Proposed Fuel Depot at Hornton Grounds former quarry (Ref. 20/02453/F - scheduled for 10 December 2020 planning meeting)

In its submission to the Planning Portal (submitted 14/10/2020) Hornton Parish Council (HPC) have raised concerns about the proposal by CERTAS to develop a fuel depot at a former quarry at Hornton Grounds.

John Offord
Chair Hornton Parish Council

Title: PROPOSED SITE LAYOUT

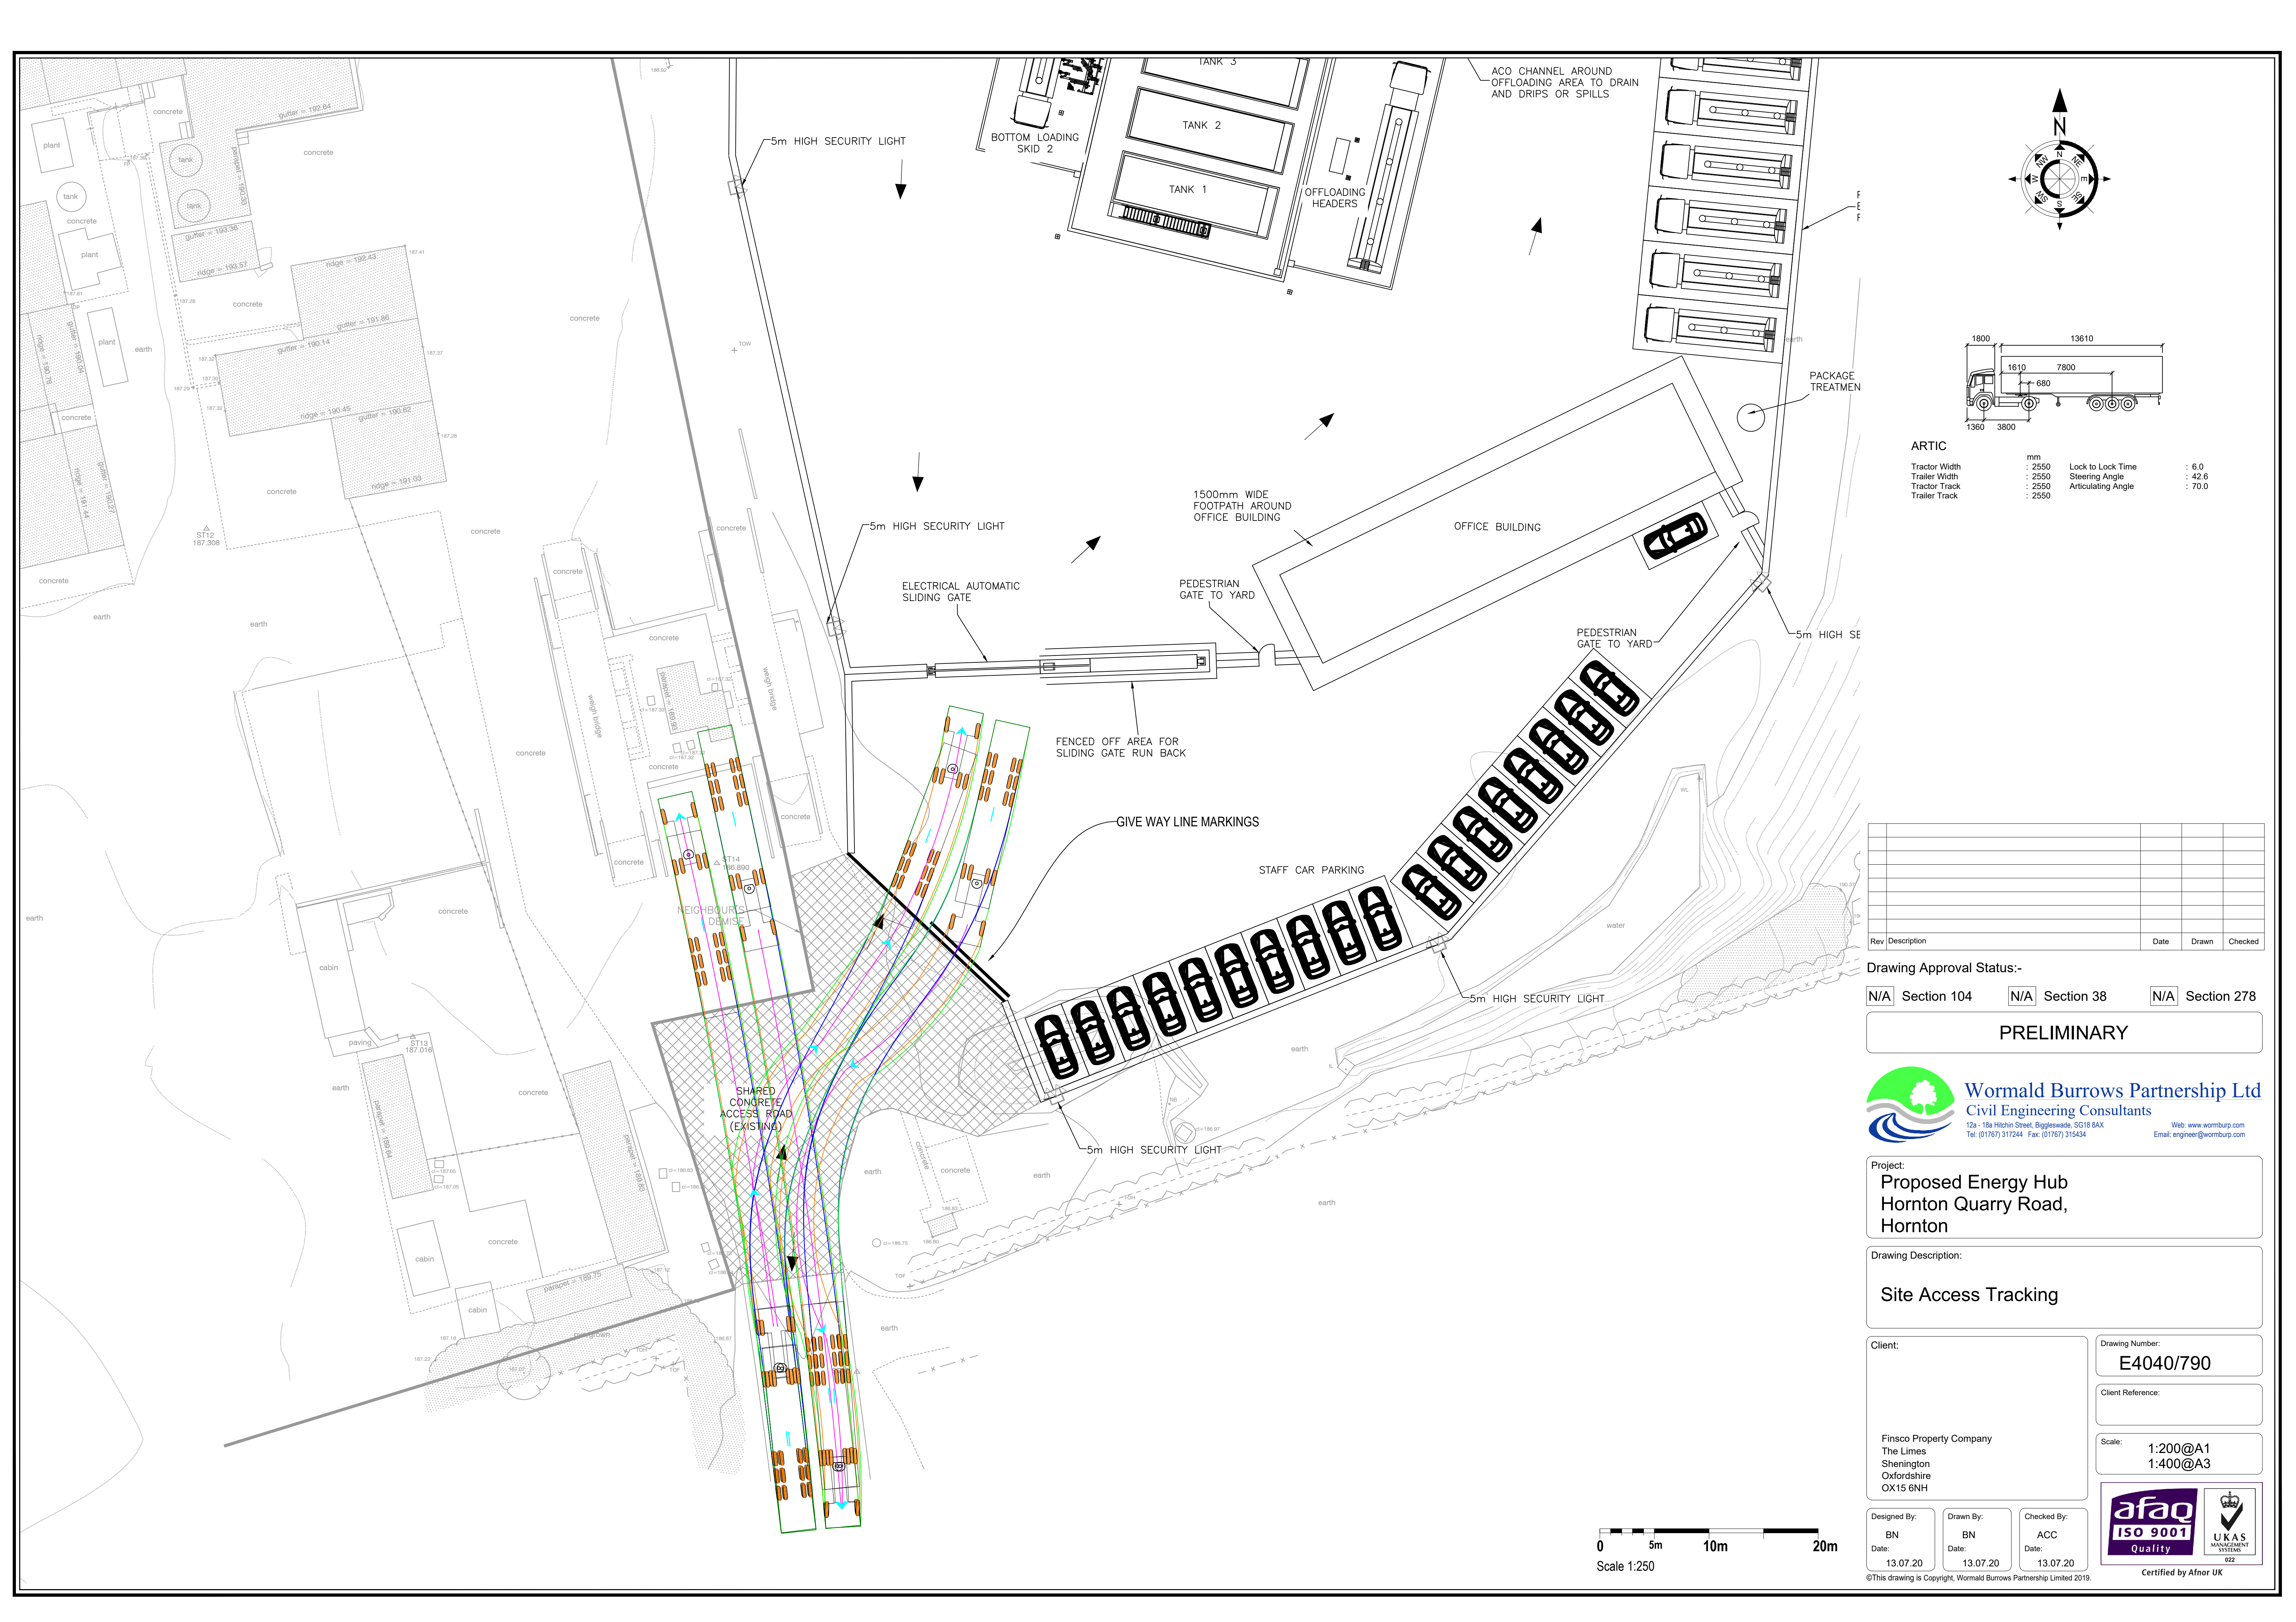
- HPC questions whether the number of future lorry movements stated in the application would be sufficient for this ambition to be achieved.
- HPC's concern that future expansion at the site is reinforced by the fact that CERTAS' proposed site plan includes the dotted outline of a 7th fuel tank.
